**Concept State Significant Development Application – SSD 18_9579 Crows Nest Overstation
Development - Submission**

I strongly object to the above application for the reasons outlined below:

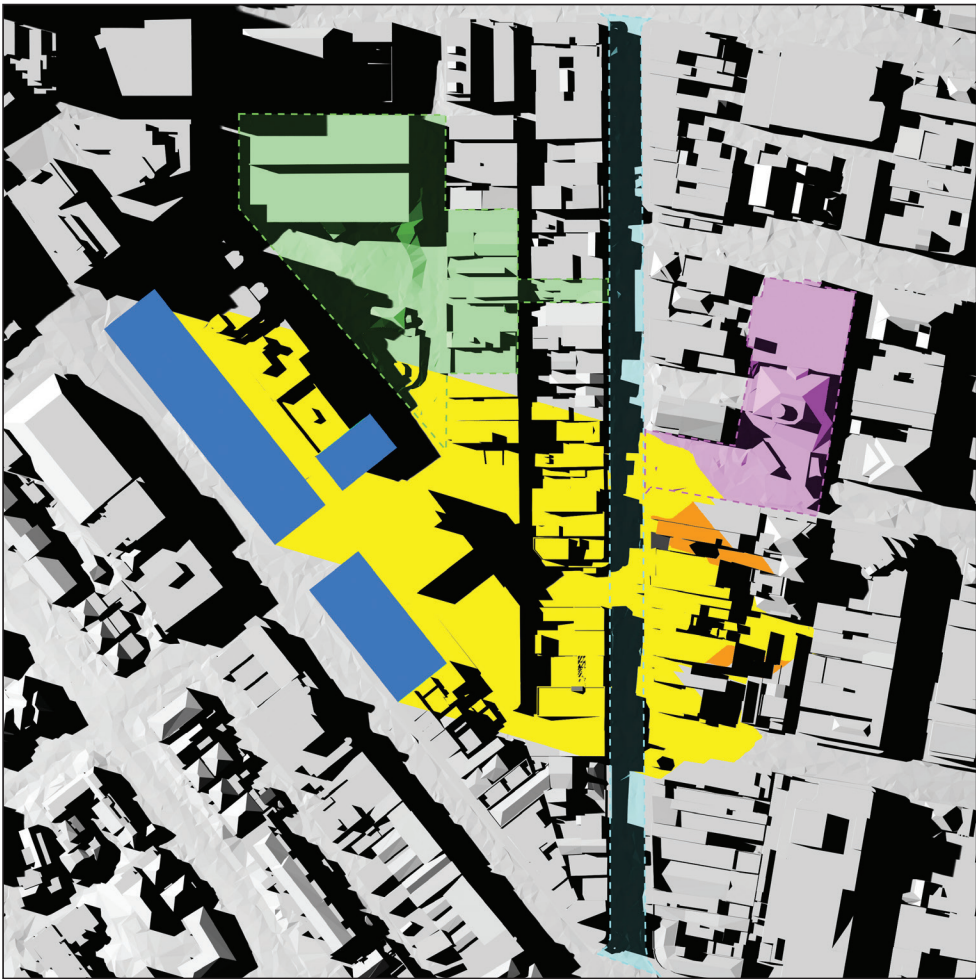
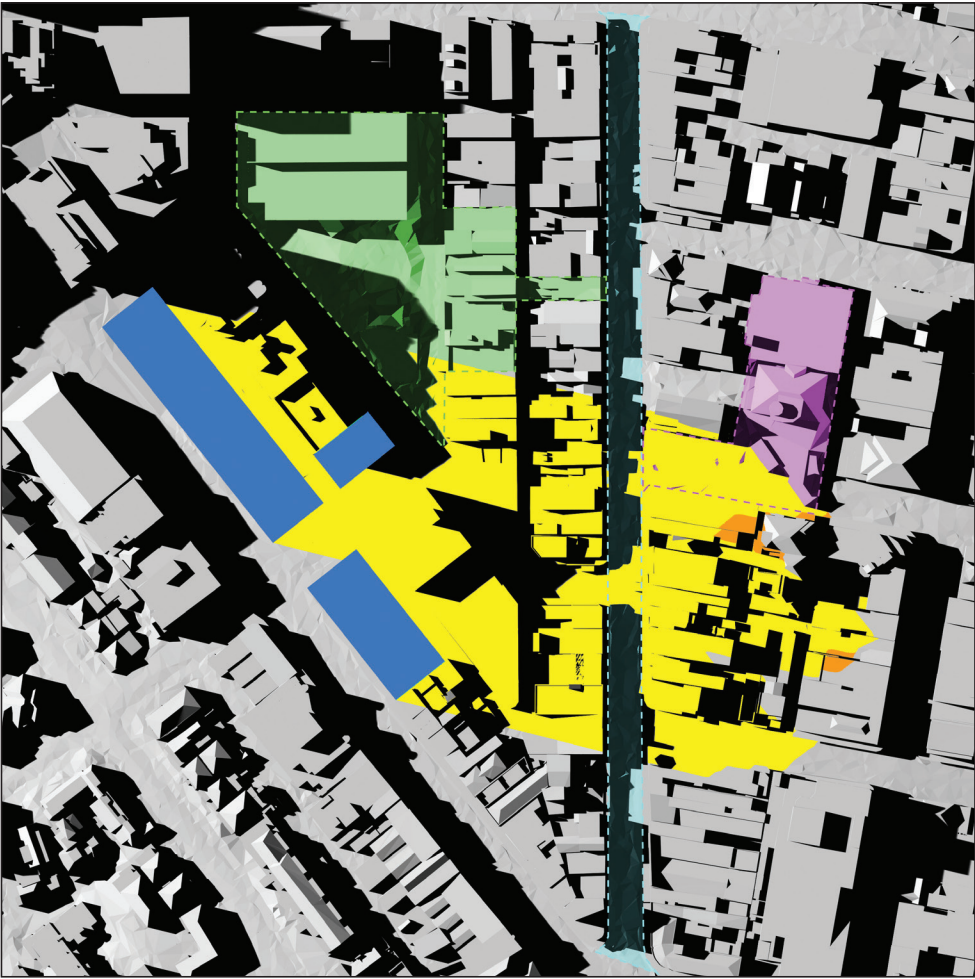
- I object to the overshadowing of Nicholson Street, Hume Street Park, Willoughby Road and Ernest Place in particular year-round, not just between 9.00 am and 3.00 pm.
